An
Bord
Pleanála

Board Direction
BD-003675-19
ABP-304346-19

The submissions on this file and the Inspector's report were considered at a Board meeting held on 31/7/2019.

The Board decided to grant permission, for the following reasons and considerations, and subject to the following conditions.

Drawing file: Block A1 & 2 / 334_A1&A2_02_00 - Ground and First Floor Plans_Block A1 & A2.pdf

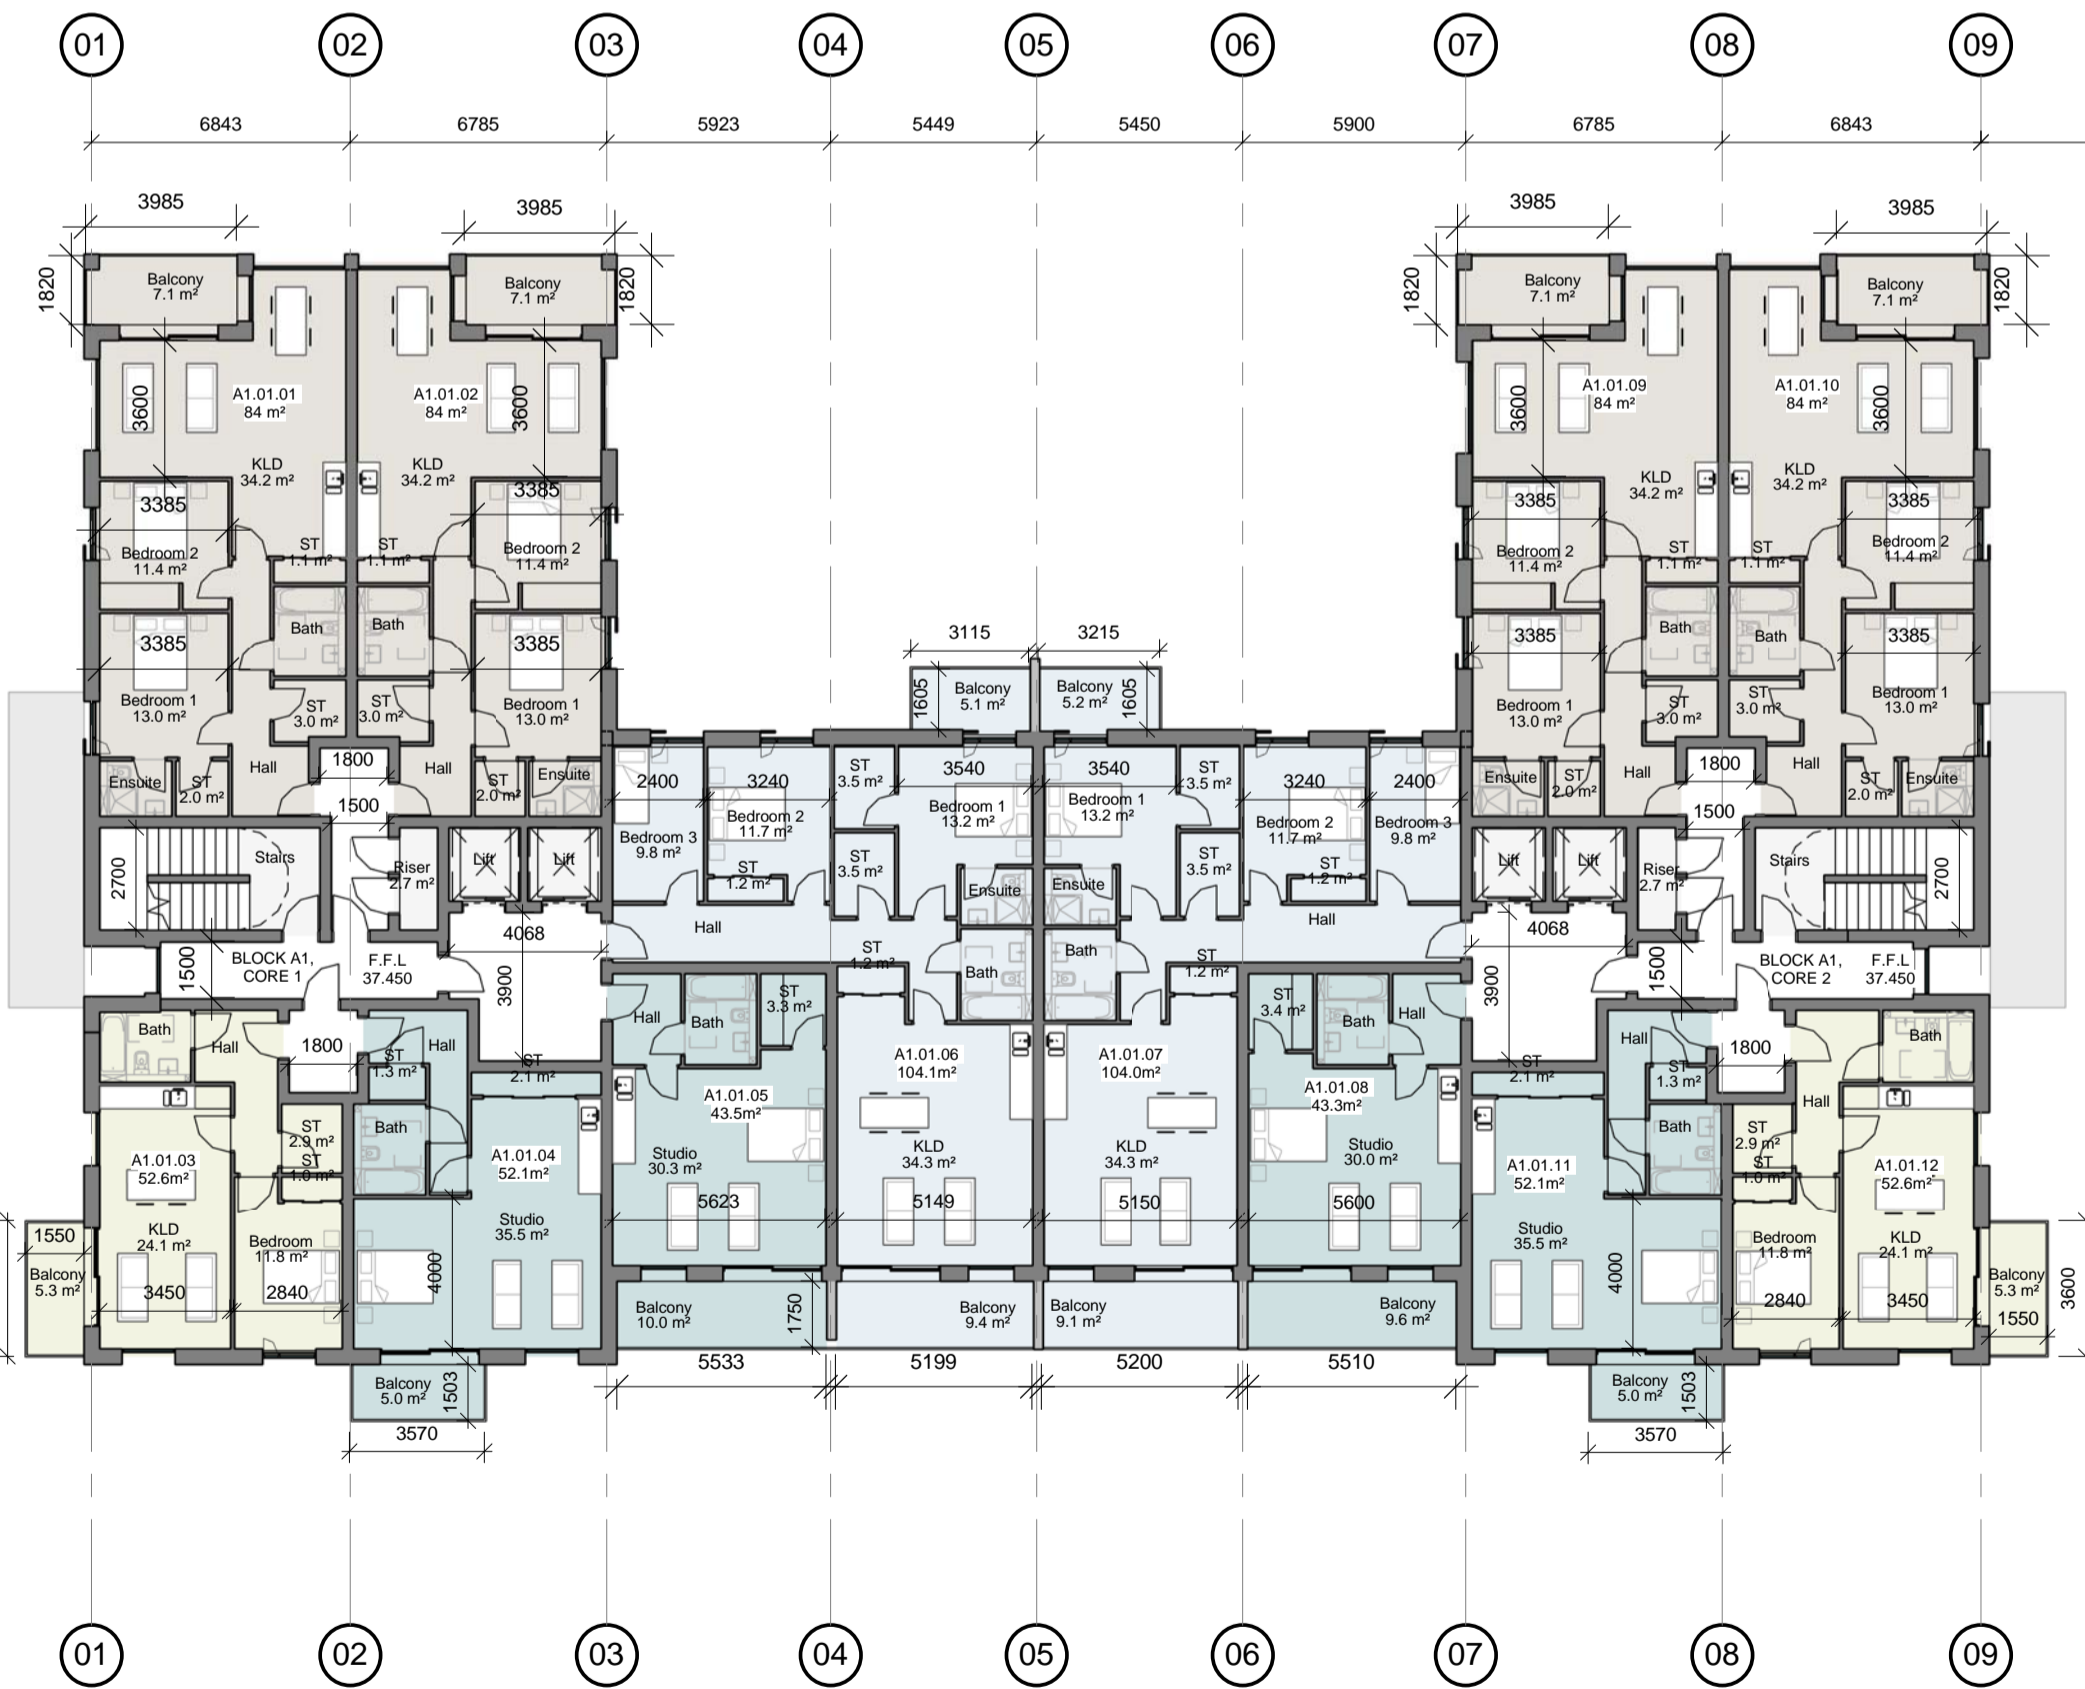
4. The proposed development shall be amended as follows;
 - The westernmost 10 storey element of Block A1 and the westernmost 10 storey element of Block A2 shall be reduced by the omission of two intermediate floors to a maximum of 8 storeys.
 - The easternmost 10 storey element of Block A1 and the easternmost 10 storey element of Block A2 shall be reduced by the omission of one intermediate floor to a maximum of 9 storeys

Revised plans and particulars shall be submitted to and agreed in writing with the planning authority prior to commencement of works.
